# Rezoning Transportation Analysis

Petition Number: 2023-071

## Revision Log:

Date	Description
8-24-23	First Review (TM)
12-19-23	Second Review (KC)
04-23-24	Third Review (IW)

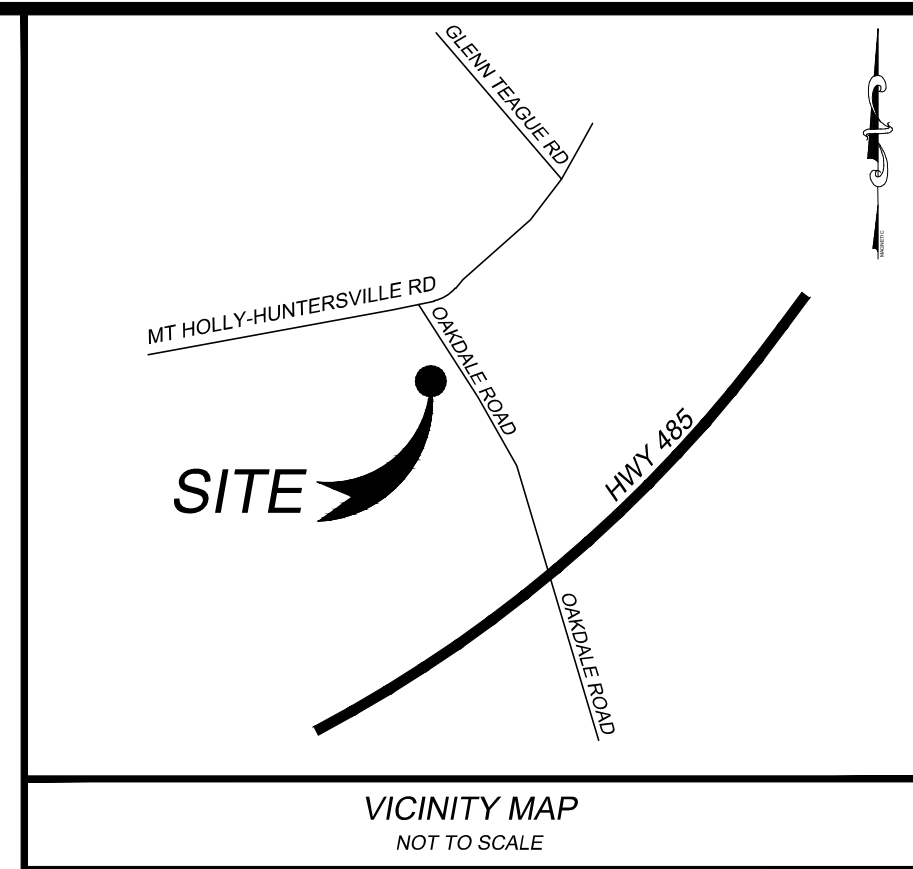
6. ~~Add a conditional note specifying "A Right-of-Way Encroachment Agreement is required for the installation of any non-standard item(s) (irrigation systems, decorative concrete pavement, brick pavers, etc.) within a proposed/existing City-maintained street right-of-way by a private individual, group, business, or homeowner's/business association. An encroachment agreement must be approved by CDOT prior to construction/installation. Contact CDOT for additional information concerning cost, submittal, and liability insurance coverage requirements."~~
7. ~~Revise site plan and conditional note(s) to commit to installing a concrete median on Oakdale Road if it is not already being constructed by development on the opposite side of development on Oakdale.~~
8. Revise site plan to show median that will be installed on Oakdale Road.
